CITY OF ALBUQUERQUE

Planning Department
Brennon Williams, Director

April 18, 2022

Re: Enterprise/ Car Wash
5700 San Mateo Blvd. NE
Traffic Circulation Layout
Architect's Stamp 03-22-22 (F18-D052)

DRAWING TITLE		
TCL		
SEAL SCOTT C. ANDERSON No. 4341 5/31/2022 REGISTERED ARCHITECT	DESIGNED	PROJECT NO
	DRAWN	SCALE
	CHECKED	DRAWING NO
	REVIEWED	DATE
5/31/2022		TCL OF

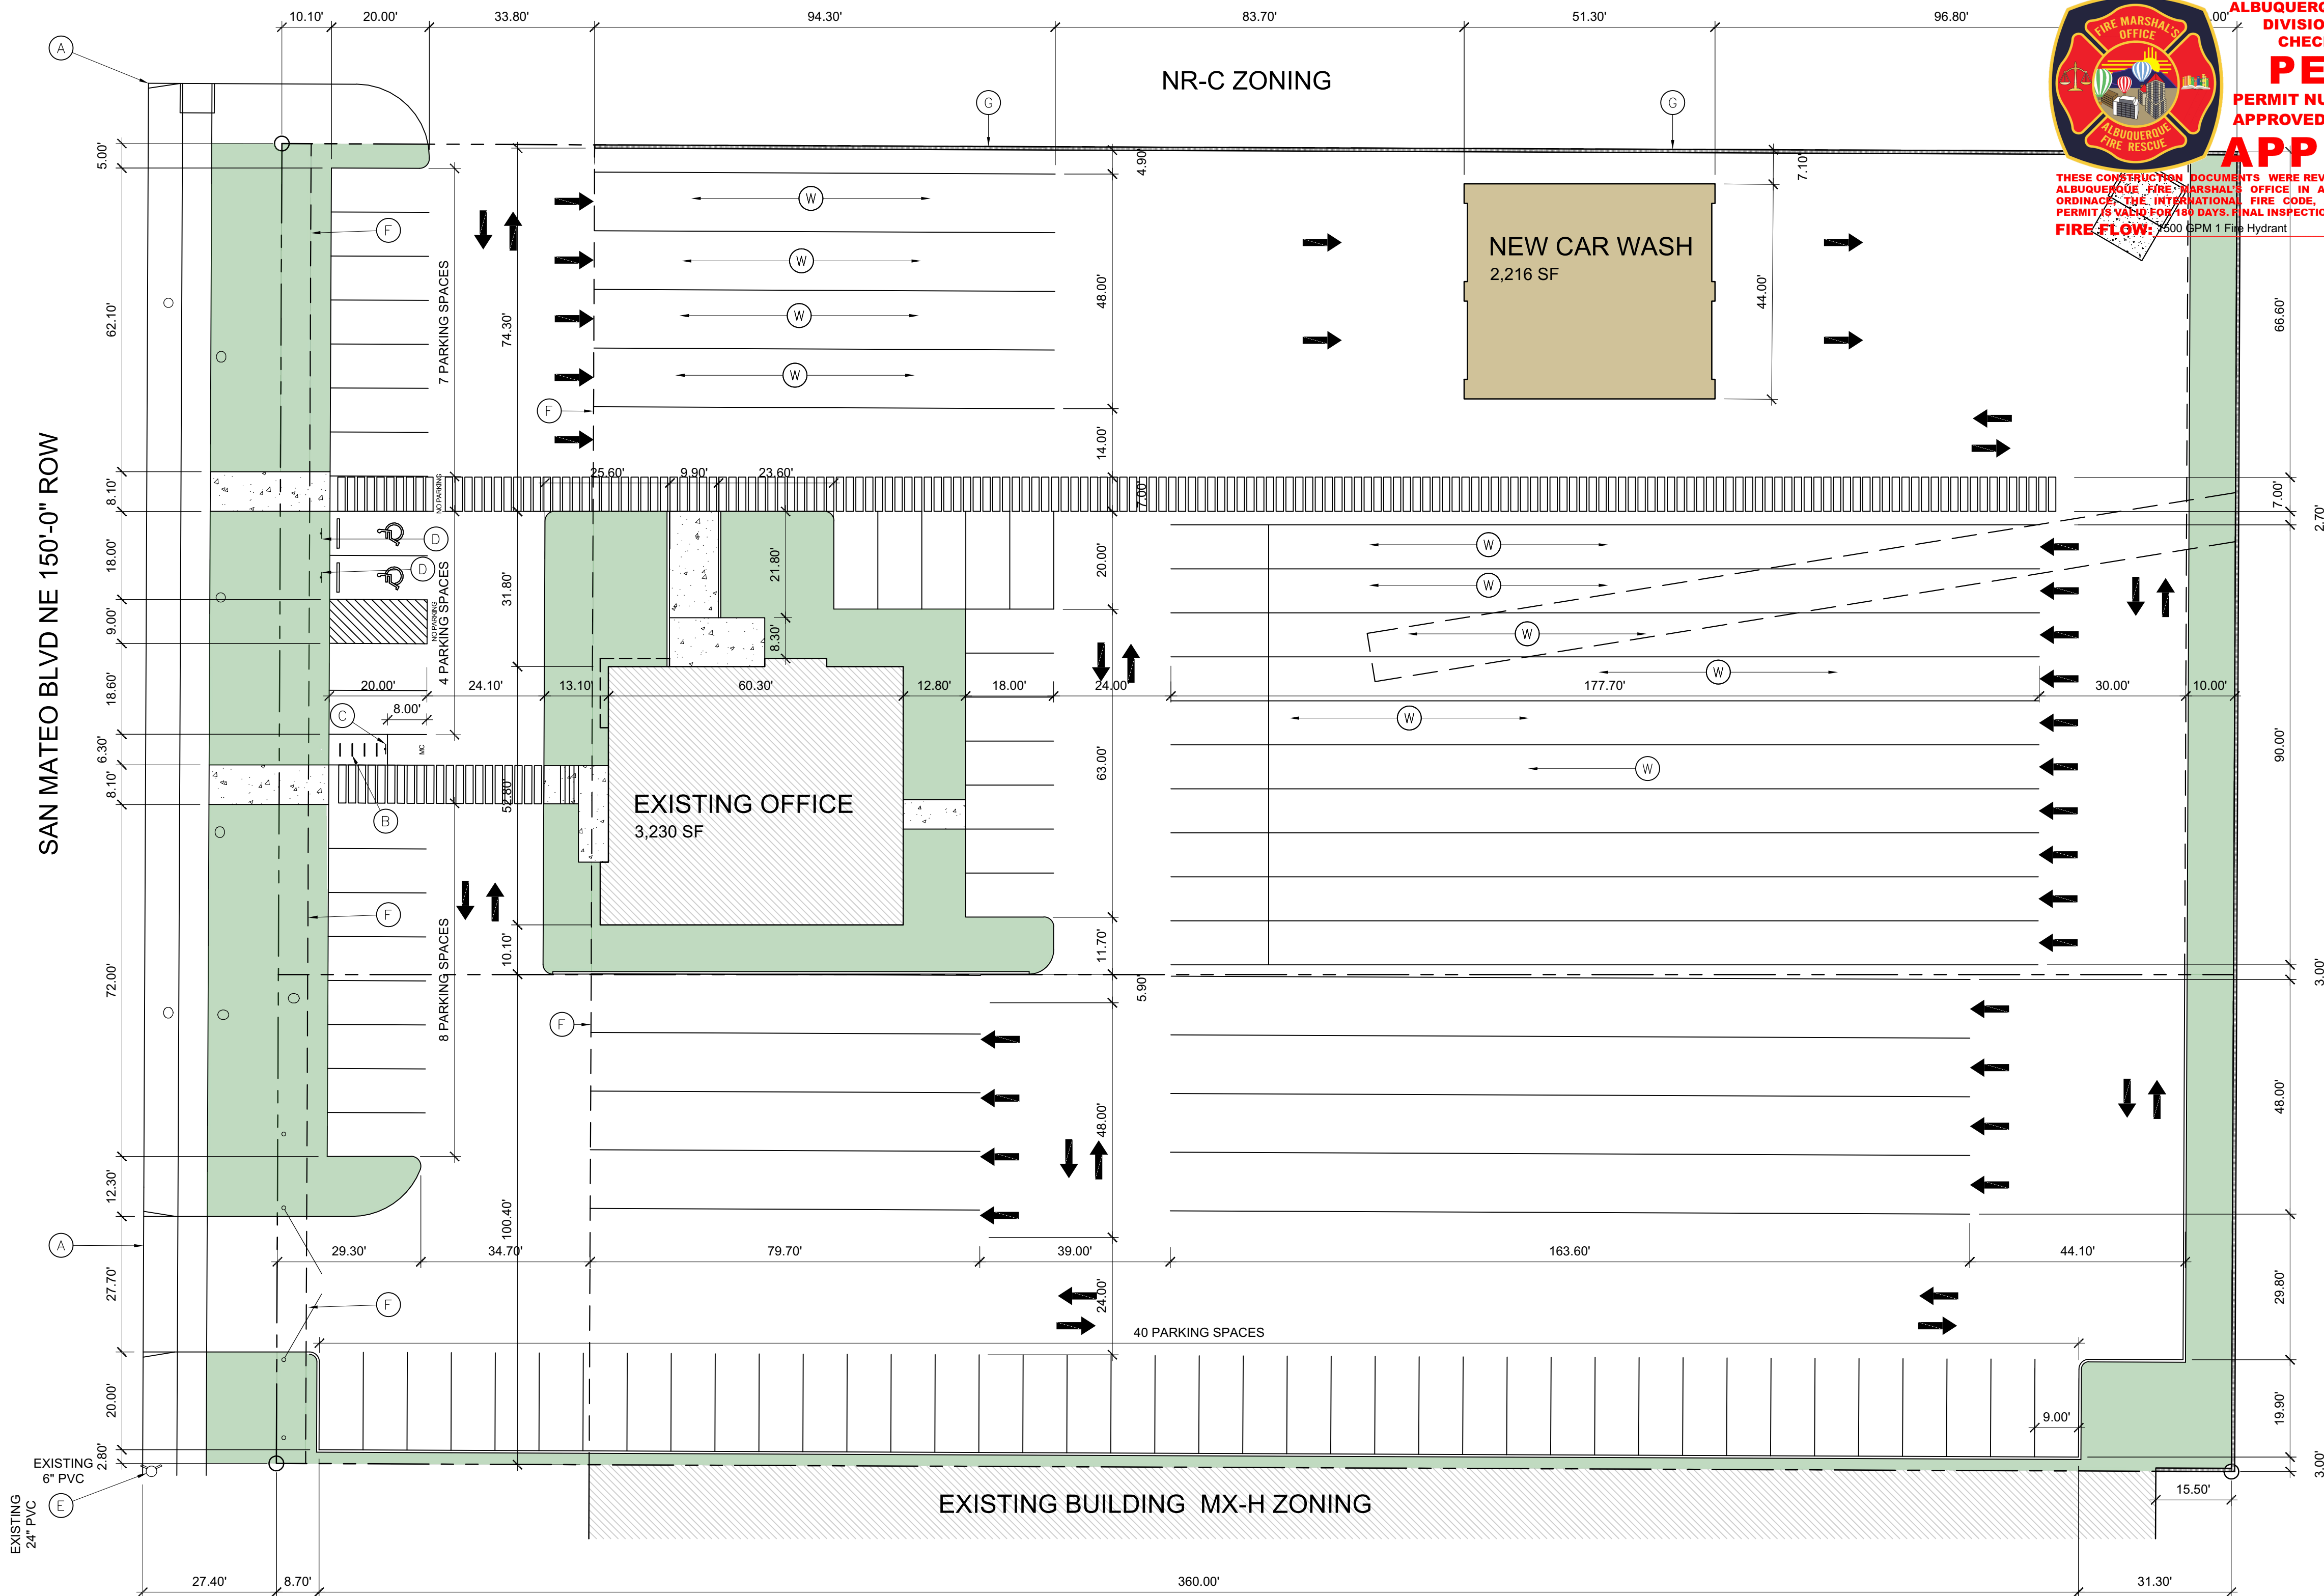
1. Driveways entrances off San Mateo Blvd. need to be updated to current ADA std. or Curb Return is recommended on Principal Arterial. San Mateo classified as Principal Arterial.
2. Maximum access width for arterial, collector, and local streets are as follows:

3. Key note K: provide details for the existing ADA ramp (dimensions, running slope, and a cross slope).
4. Per IDO Required Stacking space, you need to show minimum 3 vehicles stacking spaces in the car wash lanes.
5. Please list the width and length for all existing and proposed parking spaces. Some dimensions are not shown.
6. The minimum parking stall dimensions are:

7. The ADA accessible spaces must include an access aisle. Van accessible aisles should be 8ft wide; all others should be 5ft wide.
8. The ADA accessible parking sign must have the required language per 66-7-352.4C NMSA 1978 **"Violators Are Subject to a Fine and/or Towing."** Please call out detail and location of signs.

9. The 14' width lane between the car wash and the pedestrian pathway must be One Way.
10. All one-way drives shall have "One Way" and "Do Not Enter" signage and pavement markings. Please show detail and location of posted signs and striping.

11. Per DPM, a 6 ft. wide ADA accessible pedestrian pathway is required from each ADA parking stall access aisles to the building entrances. Please clearly show this pathway and provide details.

12. ADA accessible pedestrian pathway should not be placed behind parking space or adjacent to a vehicular way. Vehicle and pedestrian/wheel chair conflicts should be avoided as much as possible.

13. Key note W: please verify the purpose of this area, and provide proper signages to prevent cars turning into places where they shouldn't by accident

14. Curbing should be installed to delineate landscape, parking, and pedestrian ways and identify points of access. Please call out detail and location of barrier curb.

15. Parking areas shall have barriers to prevent vehicles from extending over public sidewalk, public right-of-way, or abutting lots.
16. Refuse vehicle maneuvering shall be contained on-site. The refuse vehicle shall not back into the public right of way.; provide a copy of refuse approval.

17. Provide a copy of Fire Marshal Approval.
18. It is not apparent what type of pavement surface is being proposed. A hard driving surface will be required as part of this proposed project for parking area and drive aisles.

19. Please provide a sight distance exhibit
20. Show the Intersection Sight Distance triangle and add the following note to the plan: "Landscaping and signage will not interfere with clear sight requirements. Therefore, signs, walls, trees, and shrubbery between 3 and 8 feet tall (as measured from the gutter pan) will not be acceptable in the clear sight triangle.
